## Application for a Non-Material Amendment Following a Grant of Planning Permission

Replacement dwelling house with two storeys and new basement level

63937/APP/2022/3692

Elevations 1 of 2

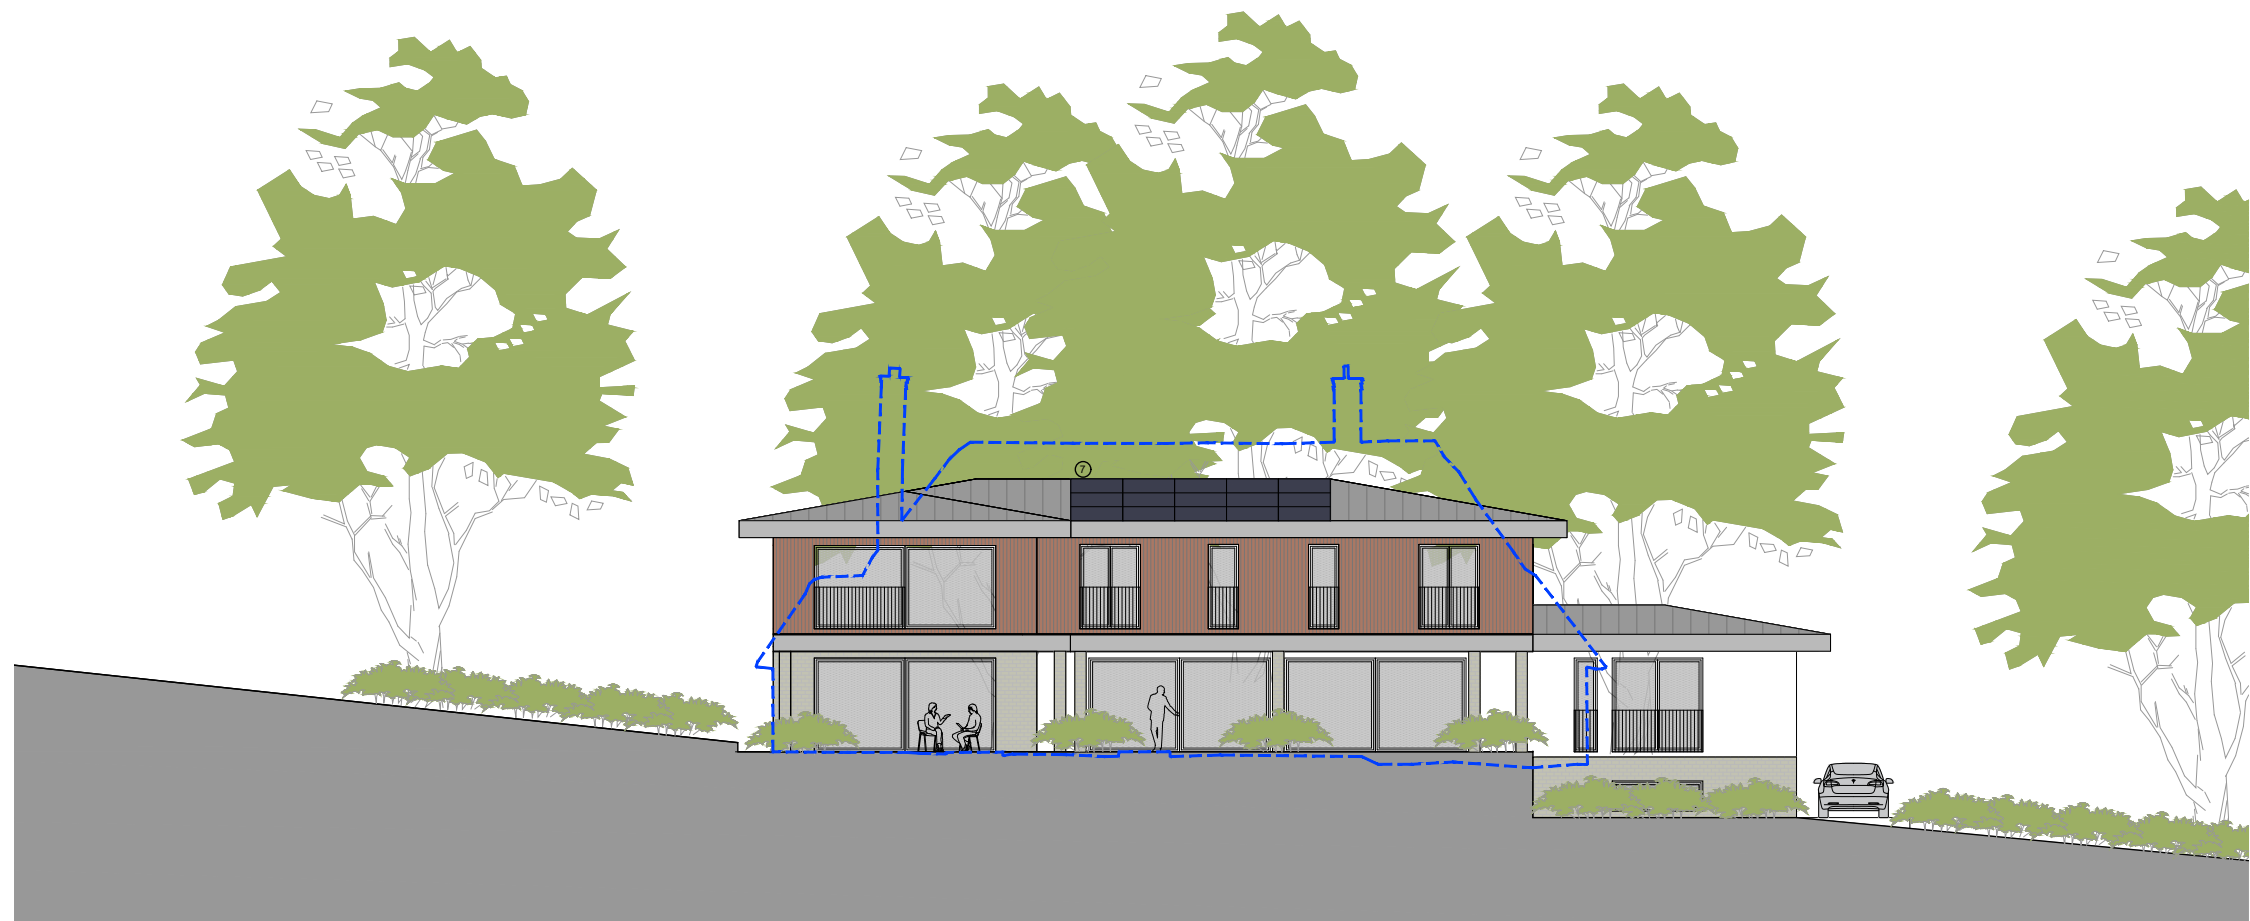
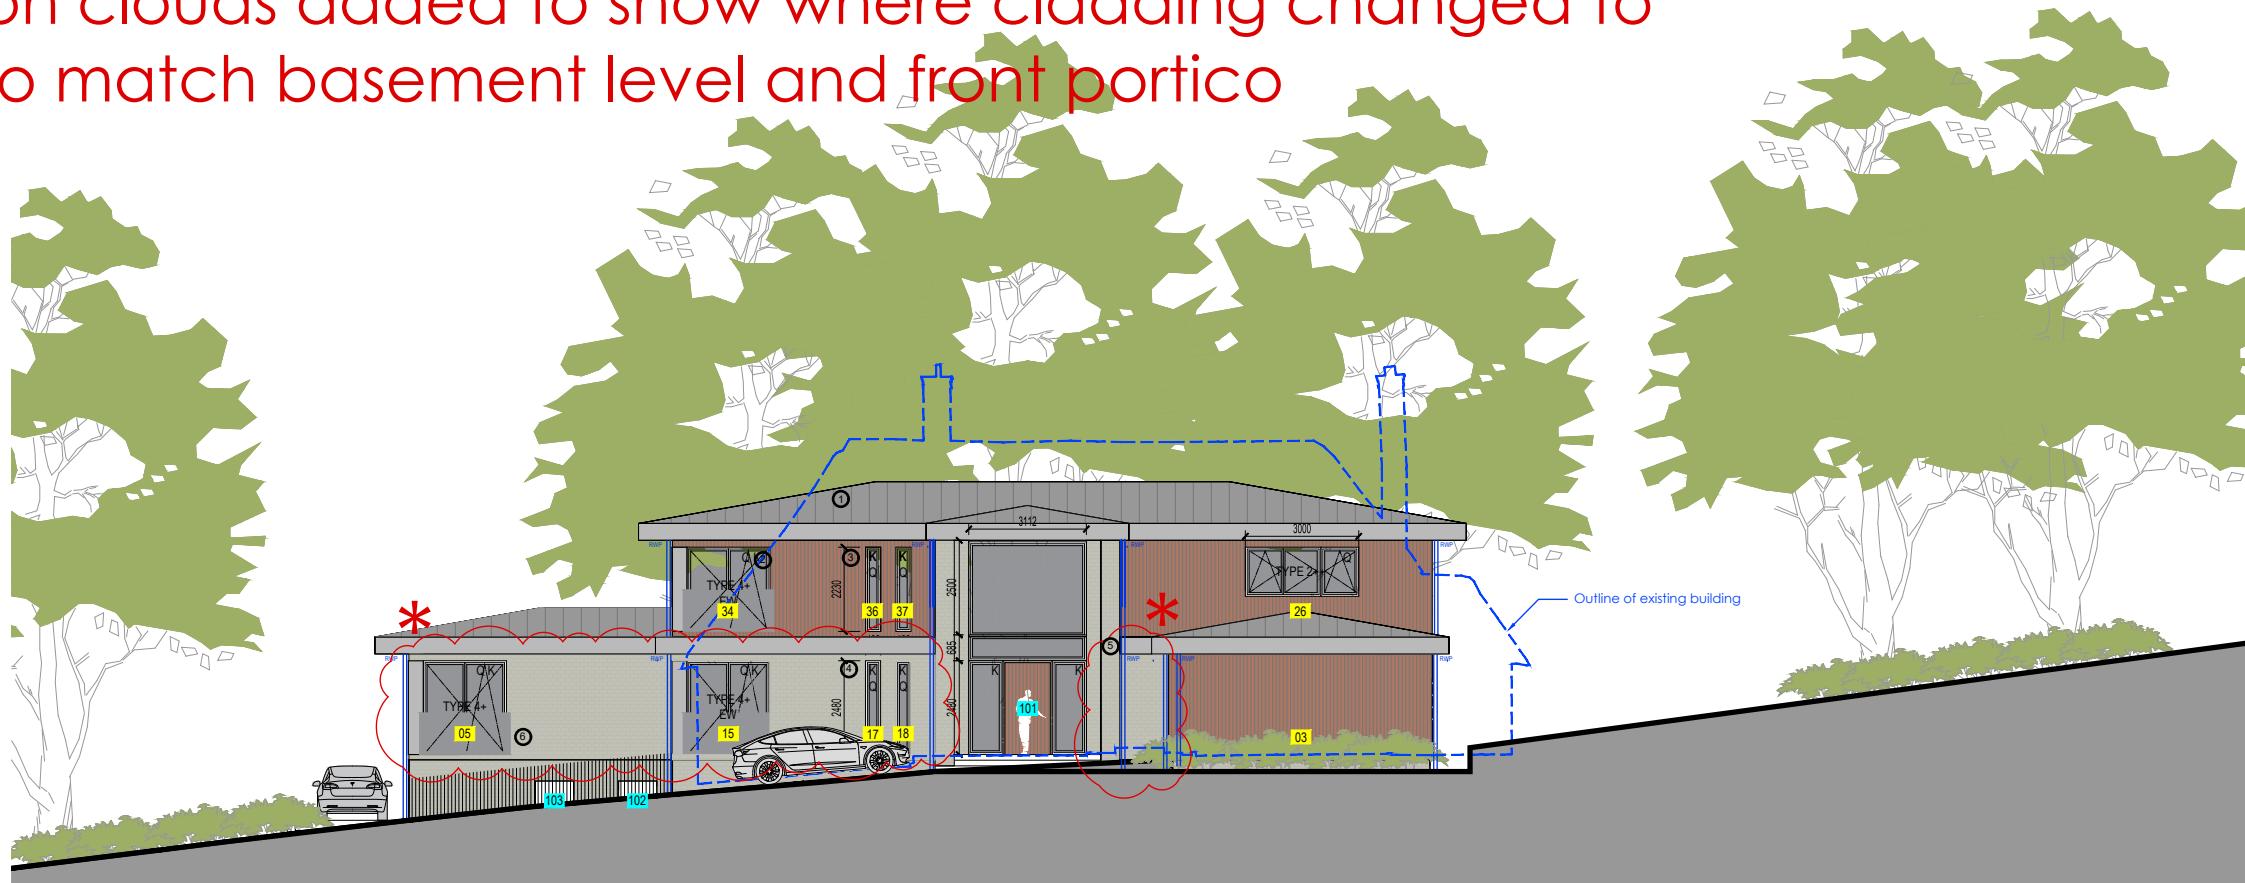
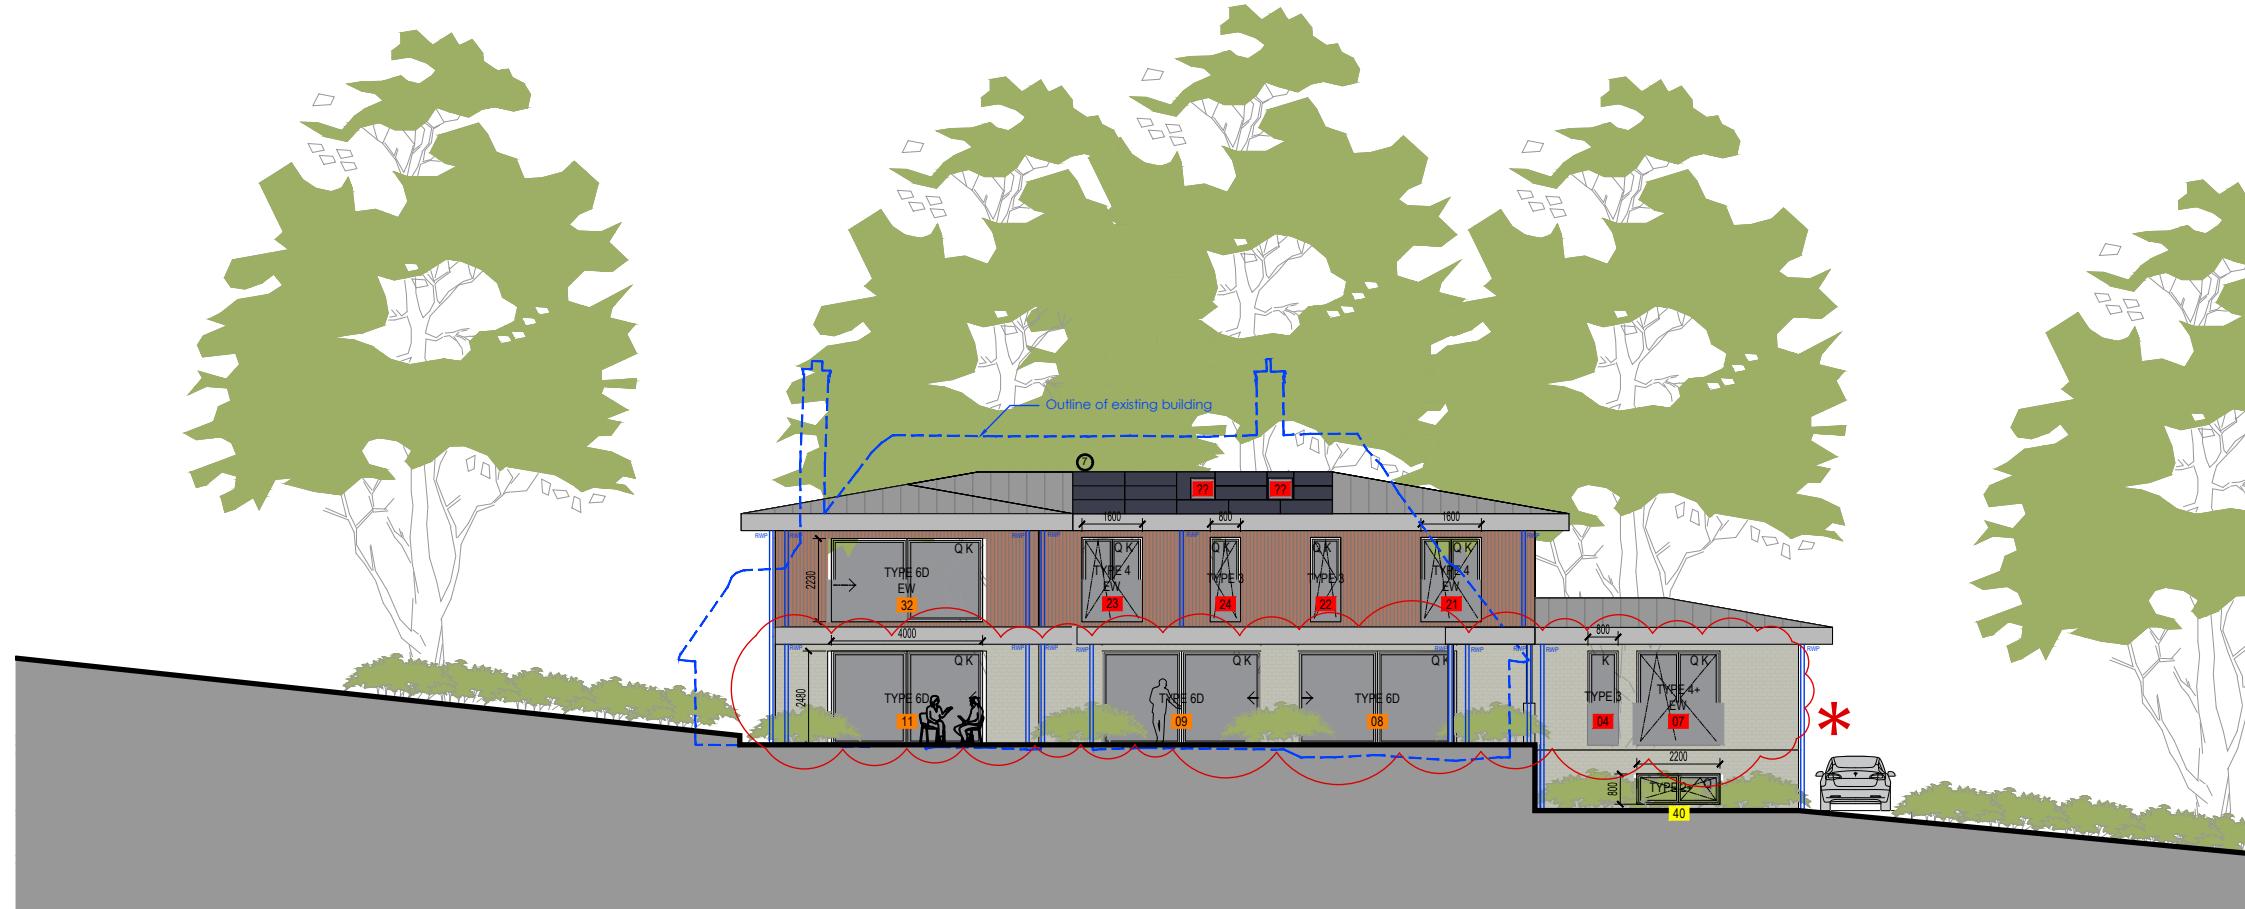
Design Development with the client during post planning meeting. The Eternit-type panels have been removed so as to simplify and enhance the elevations from quite busy facades with ave. 3 materials / finishes +glazing to 2 materials / finishes + glazing.

375-006-0 ELEVATIONS - SHEET 1  
375-006-0 ELEVATIONS - SHEET 2

375-006-D: ELEVATIONS - SHEET 1  
375-006-D: ELEVATIONS - SHEET 2
